**WELWYN HATFIELD BOROUGH COUNCIL  
ASSISTANT DIRECTOR (PLANNING)**

**DELEGATED APPLICATION**

**Application No:** 6/2022/2823/HOUSE  
**Location:** 1 Lysley Place Brookmans Park AL9 6NZ  
**Proposal:** Retention of alteration to external materials of window frames and roof tiles and proposed alterations to external materials of external cladding with alterations to fenestration  
**Officer:** Ms Kirsty Shirley

South-East Elevation (front)

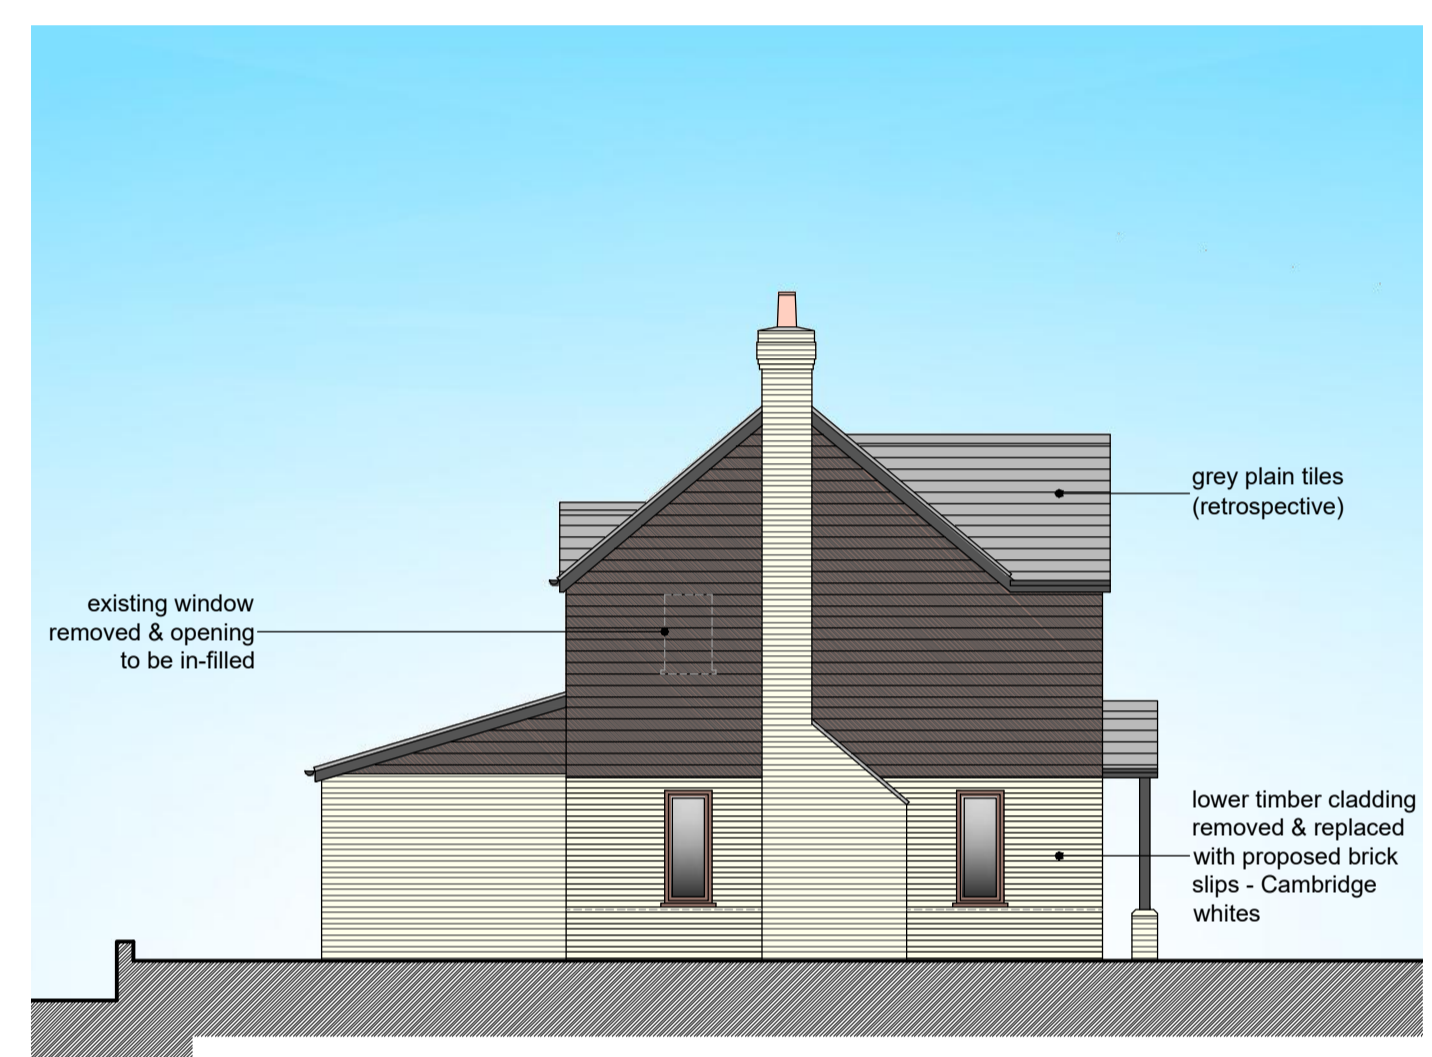
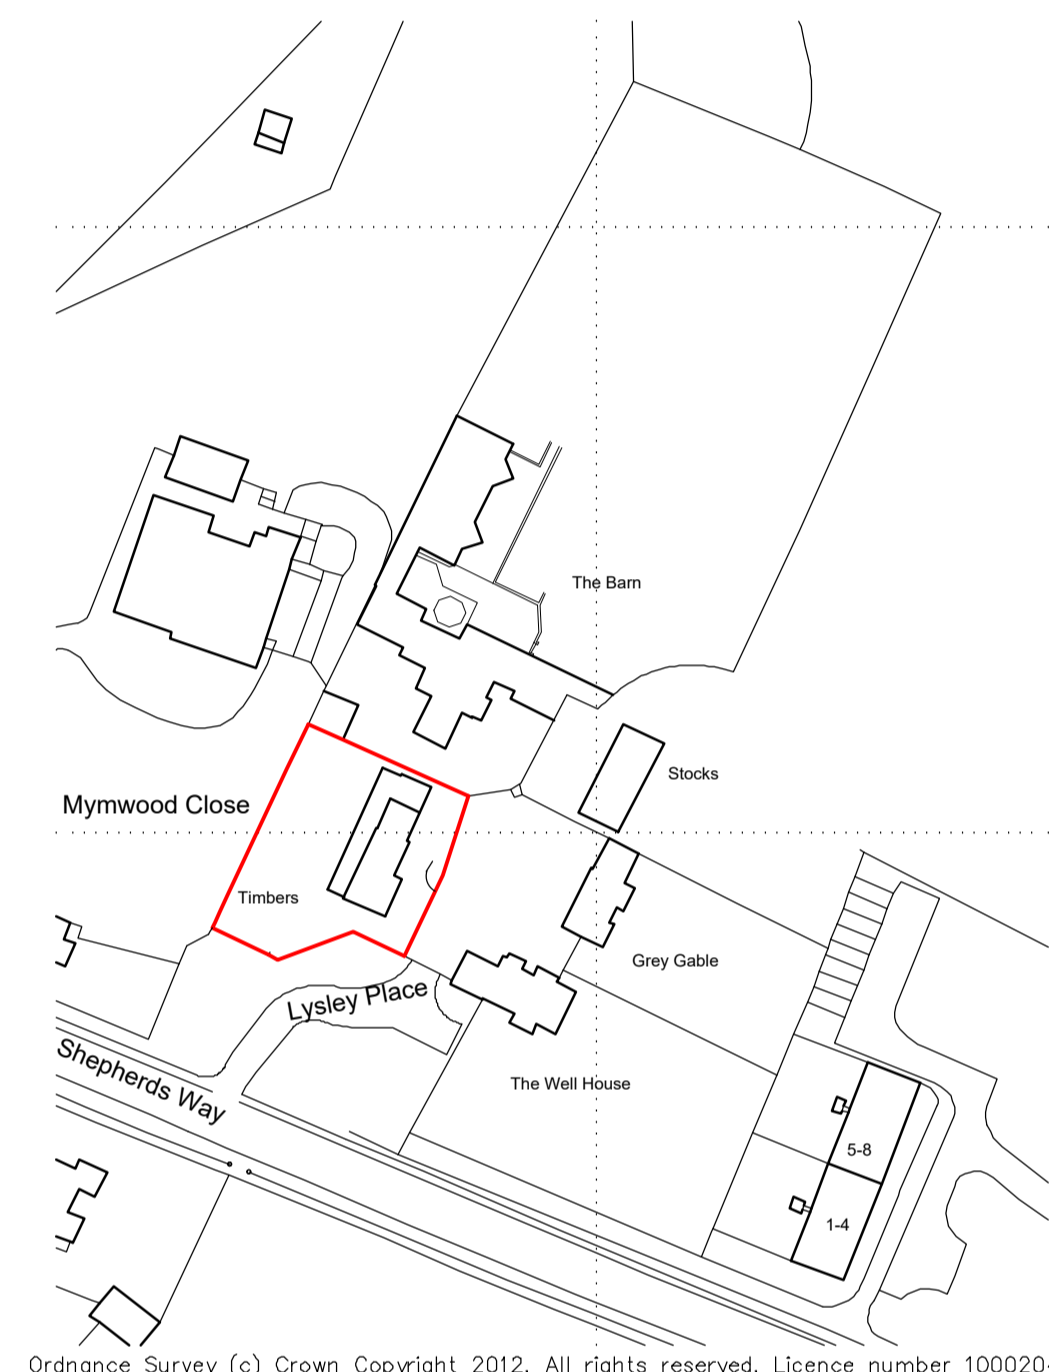
The proposal includes replacing the lower half of the timber cladding on the dwelling with Cambridge White brick slips and retaining timber boarding to the top half in dark brown. The positioning of the timber and brick slip cladding would be replicated across all the elevations of dwelling.

During the site visit, samples of the materials were assessed and photographed, and are in accordance with the description annotated onto the submitted plans. The proposed alterations would not detract from the character and appearance of the application dwelling or properties located in Lysley Place and would appear sympathetic and traditional adjacent to the listed buildings.

It is noted in the south-west elevation, a first-floor window would be removed and in-filled. This window does not overlook any neighbours and no additional windows are proposed as part of this proposal. The privacy of adjoining neighbours would therefore be maintained as a result of this development.
